REQUEST

Current Zoning: N1-A ANDO (Neighborhood 1, Airport Noise Disclosure Overlay)
Proposed Zoning: I-1(CD) ANDO (Light Industrial, Conditional, Airport Noise Disclosure Overlay)

Approximately 10.34 acres located north of Shopton Road, east of Sandy Porter Road, and west of Pinecrest Drive.

The petition proposes to allow 120,200 square feet of gross floor area of warehousing, warehouse distribution, manufacturing, office and other industrial uses permitted in the I-1 zoning district on two properties partially developed with single family detached dwellings.

**RZ-1**  
Sheet 1 of 2

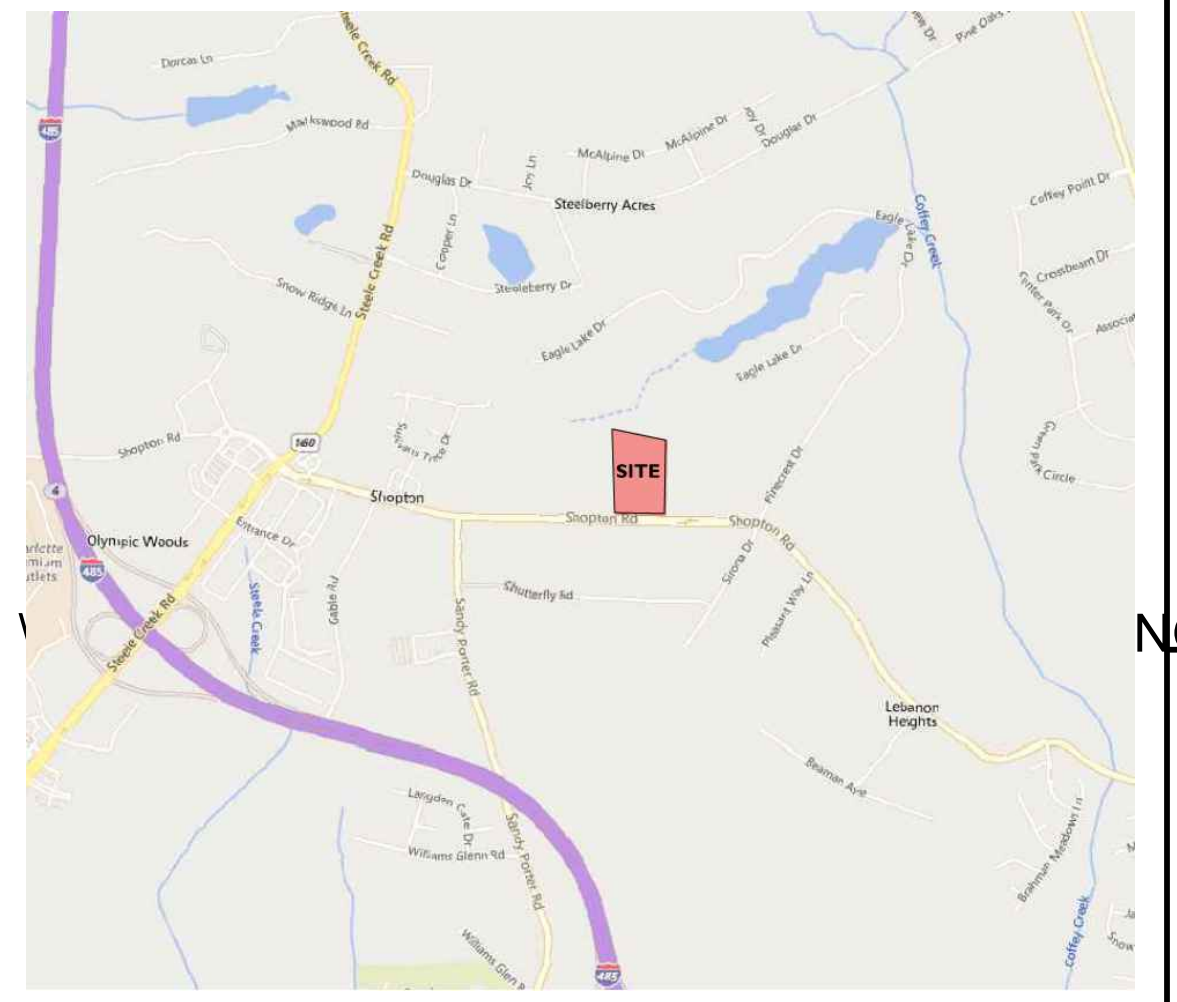
- ~~1. Label and dimension the right of way from the road centerline.~~ **ADDRESSED**
- ~~2. Revise site plan and conditional note(s) to commit to construct an 8-foot planting strip, and 8-foot sidewalk on Shopton Road per Chapter 19. The site plan shall label and dimension both items from the back of curb and gutter or edge of pavement.~~ **ADDRESSED**
- ~~3. Revise site plan and conditional note(s) to commit to construct bicycle facilities by locating the curb and gutter 27' from the center line to meet the Council-adopted Charlotte BIKES Policy. Revise the bike lane to 5' wide with a 3' buffer.~~ **ADDRESSED**
- ~~4. Per coordination with NCDOT, revise site plan and conditional note(s) to commit to installing a left turn lane into the site from Shopton Road. Show left turn lane or two-way left turn lane on site plan.~~ **ADDRESSED**

- 5. ~~Per coordination with NCDOT, revise the site plan to remove the sites eastern access. Line access up with the driveway across the street.~~ ADDRESSED
- 6. ~~Revise site plan to remove truck apron and widen driveway to accommodate appropriate turning movements. Add conditional note for driveway design to be finalized during permitting as approved by CDOT/NCDOT.~~ ADDRESSED

- 7. ~~Add the following uses to the list of prohibited uses in the conditional notes: automobile service stations, automotive repair garages, junk yards, petroleum storage facilities, landfills, and quarries.~~ ADDRESSED
-
